The Member-Secretary,  
Madras Metropolitan  
Development Authority,  
No.8, Gandhi-Irwin Road,  
Madras-600 008.

Letter No. **A1/26721/90**

Sub: **MMDA - Planning Permission - Construction  
of Residential building in Plot No.9  
at S.No. 260part of Porur village -  
Approved - Regarding.**

GROUND FLOOR PLAN

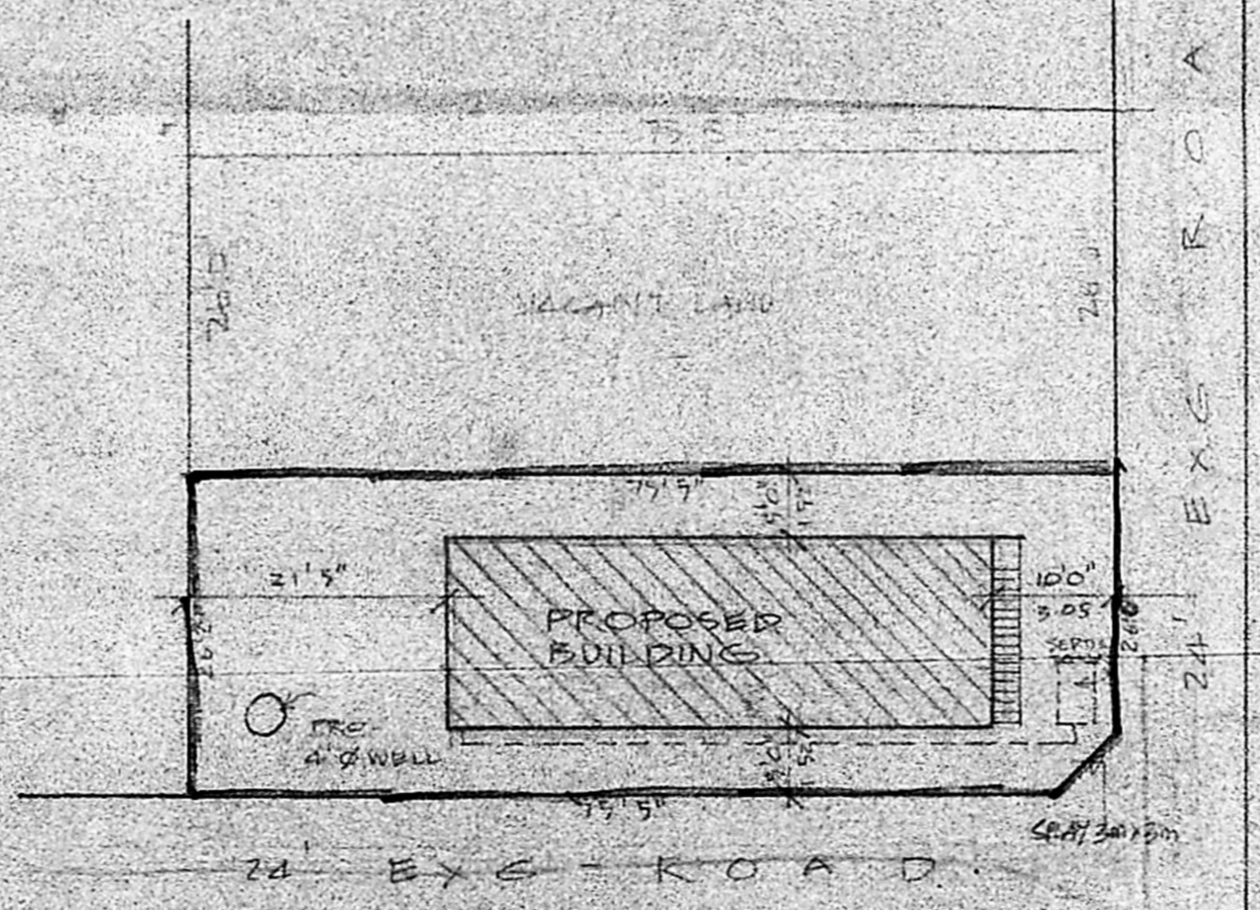
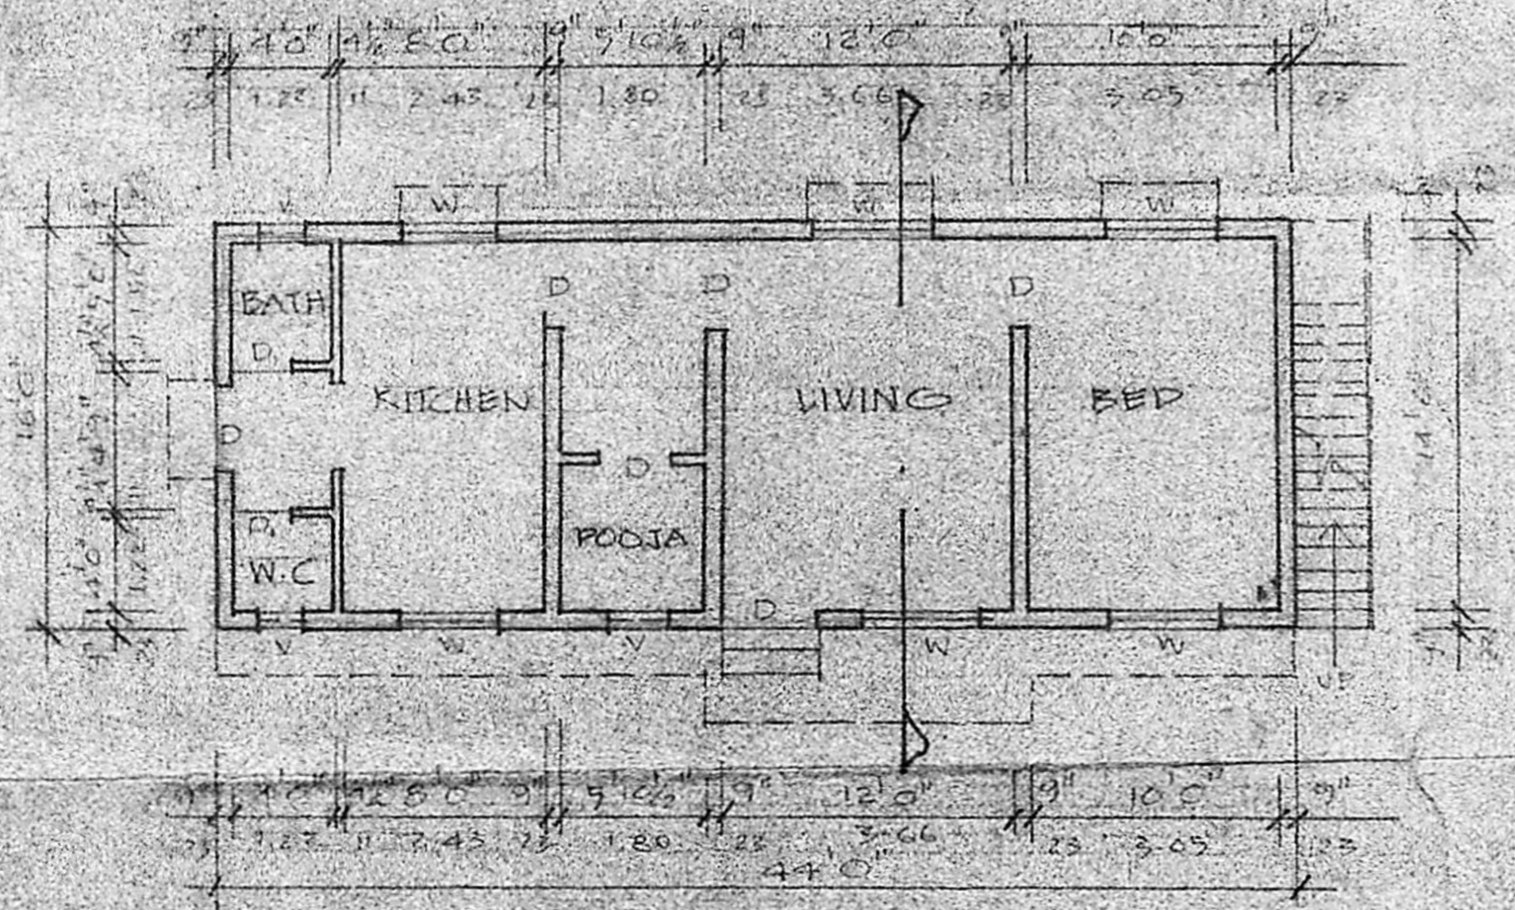
towards Regularisation charge by two separate Demand Draft  
of a Nationalised Bank in Madras City drawn in favour of the  
Member-Secretary, MMDA, Madras-8 or in cash/and pay at MMDA  
office Cash Counter between 10.00 A.M. and 4.00 P.M. within  
10 days and after remit the said amount, you are requested to  
remit the duplicate receipt to Area Plans Unit. You are also  
requested to submit the Affidavit for ULC in Rs.5/- Stamp  
paper duly attested by Notary Public. Planning Permission  
application will be returned unapproved if the amount are not  
paid within the stipulated time. You are also requested to furnish  
copies of revised plan showing splay of 3.0M x 3.0M, Affidavit  
and Indemnity Bond duly notarised.
